## Application by Photovolt Development Partners on behalf of Solar Five Limited (the Applicant) for an Order Granting Development Consent for the Botley West Solar Farm

**The Examining Authority's second written questions and requests for information (ExQ2): Issued on 30 July 2025**

- Order Limits:
- Cable Corridor:
- Cable Corridor Option:
- Indicative HDD Entry / Exit Pit:

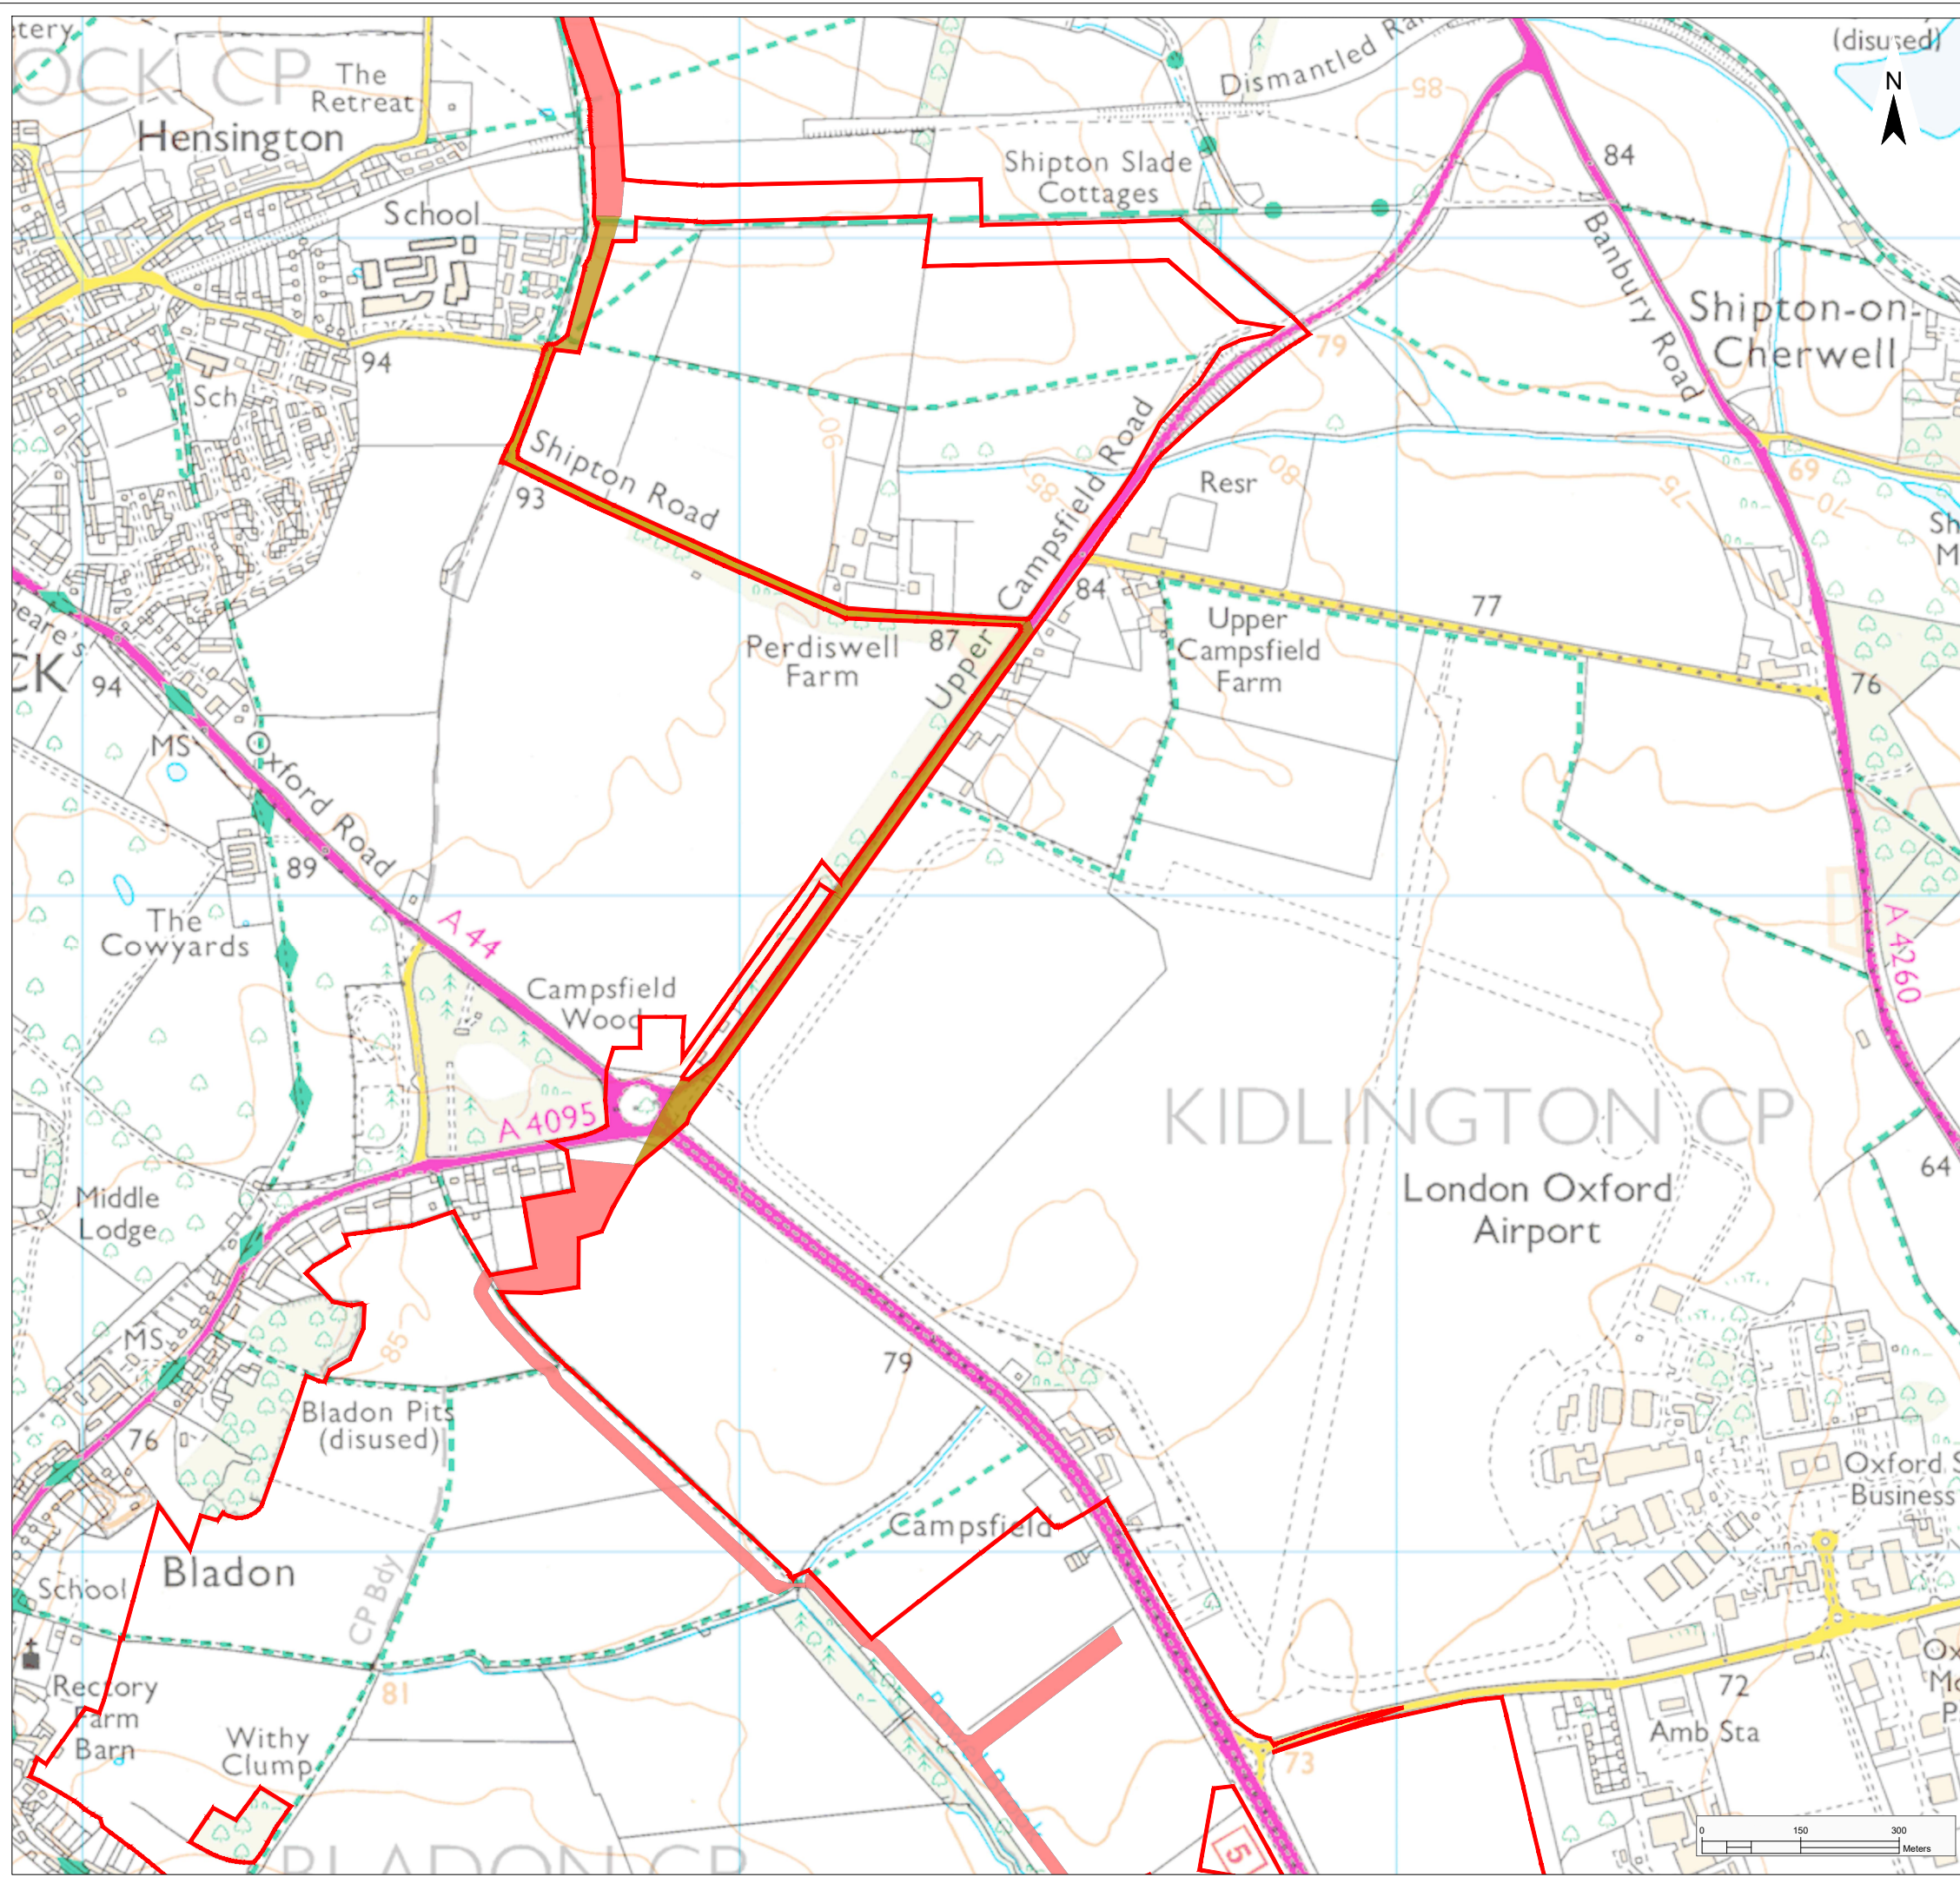
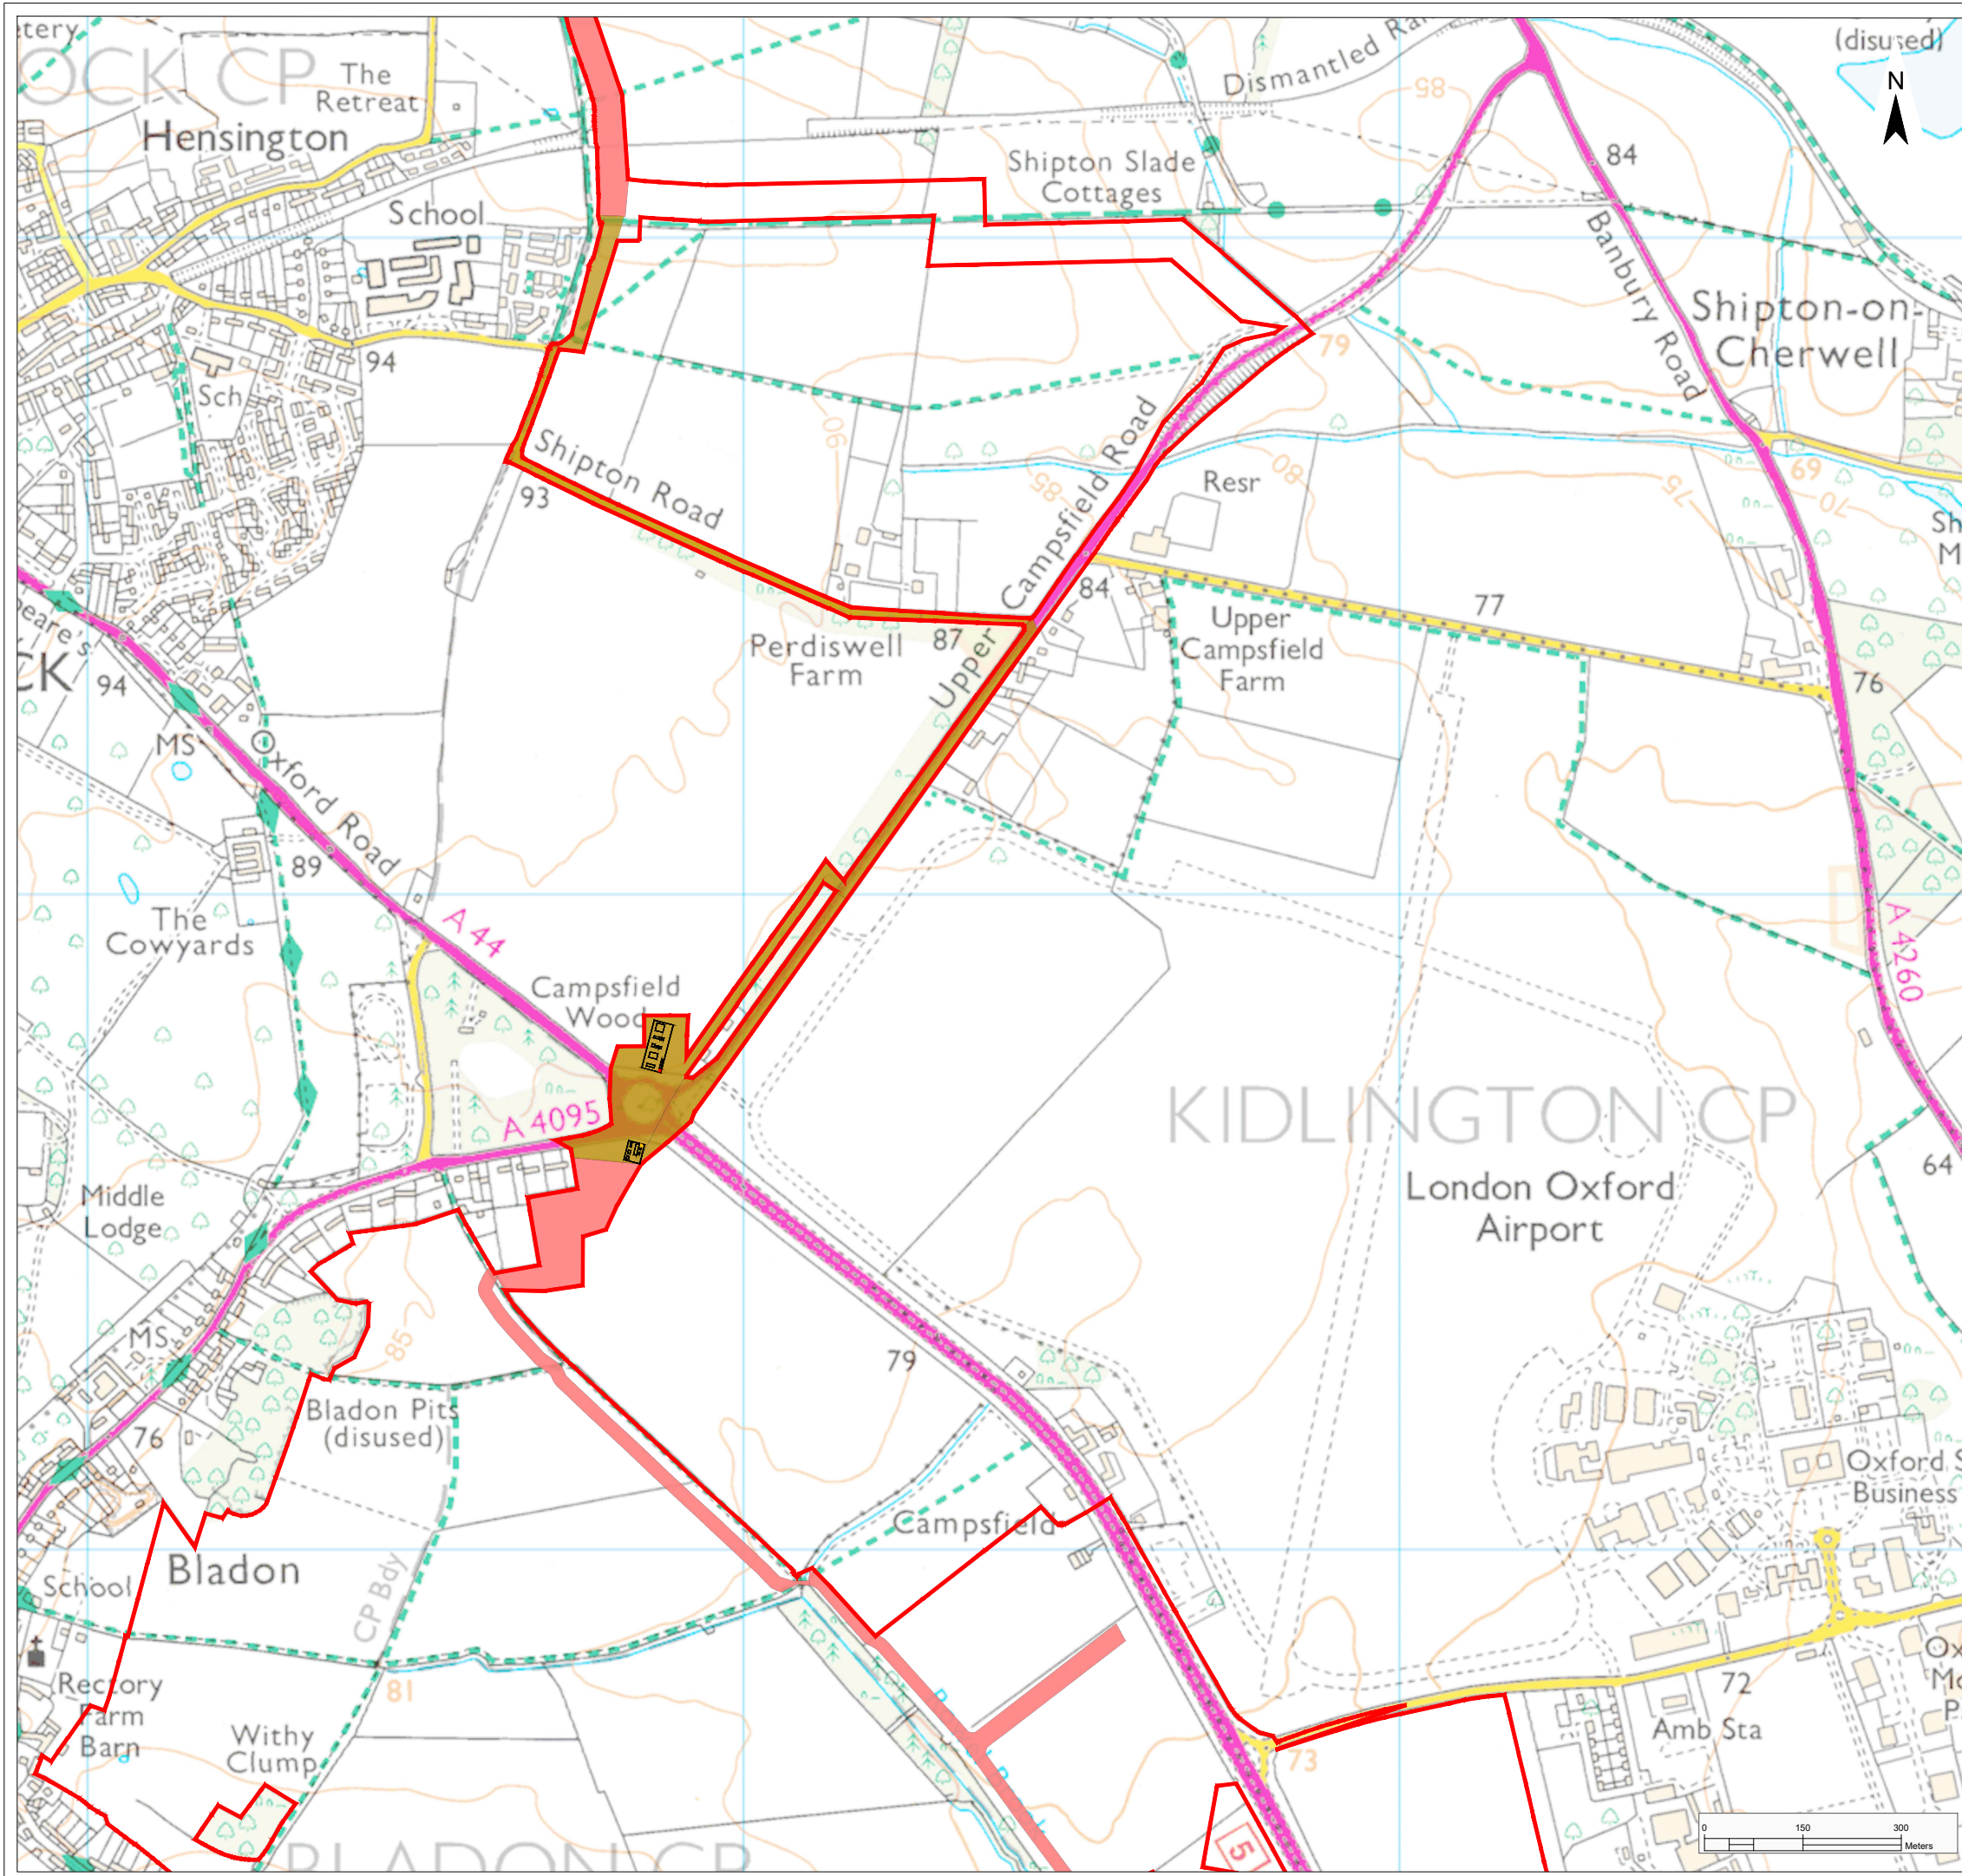
2.3.4	Applicant	<p><b>Cable corridor</b></p> <p>In response to ExQ1.3.10 [REP2-025], it is stated that any formal request to remove residual optionality (for the cable routing options) from the Order limits is unlikely until the outstanding surveys and agreements are concluded, which is expected in the post-consent phase. Explain:</p> <ol style="list-style-type: none"> <li>1) Who would be notified of the cable routeing decision outcomes and when.</li> <li>2) How would the discarded options be managed post-consent (i.e. for example is it just a case of not exercising Compulsory Acquisition powers)?</li> <li>3) Have any surveys or investigations to date indicated a potential preference in cable corridor routeing?</li> </ol> <p>Should the optionality, or at least the decisions in relation to the optionality, be subject of a Requirement that would secure a choice of cable routeing that subsequently prevents other options from also being pursued?</p>

2.3.8	Applicant	<p><b>Cable corridor</b></p> <p>In response to ExQ1.3.10 [REP2-025], it is stated that any formal request to remove residual optionality (for the cable routing options) from the Order limits is unlikely until the outstanding surveys and agreements are concluded, which is expected in the post-consent phase. Explain:</p> <ol style="list-style-type: none"> <li>1) Who would be notified of the cable routeing decision outcomes and when.</li> <li>2) How would the discarded options be managed post-consent (i.e. for example is it just a case of not exercising Compulsory Acquisition powers)?</li> <li>3) Have any surveys or investigations to date indicated a potential preference in cable corridor routeing?</li> </ol> <p>Should the optionality, or at least the decisions in relation to the optionality, be subject of a Requirement that would secure a choice of cable routeing that subsequently prevents other options from also being pursued?</p>
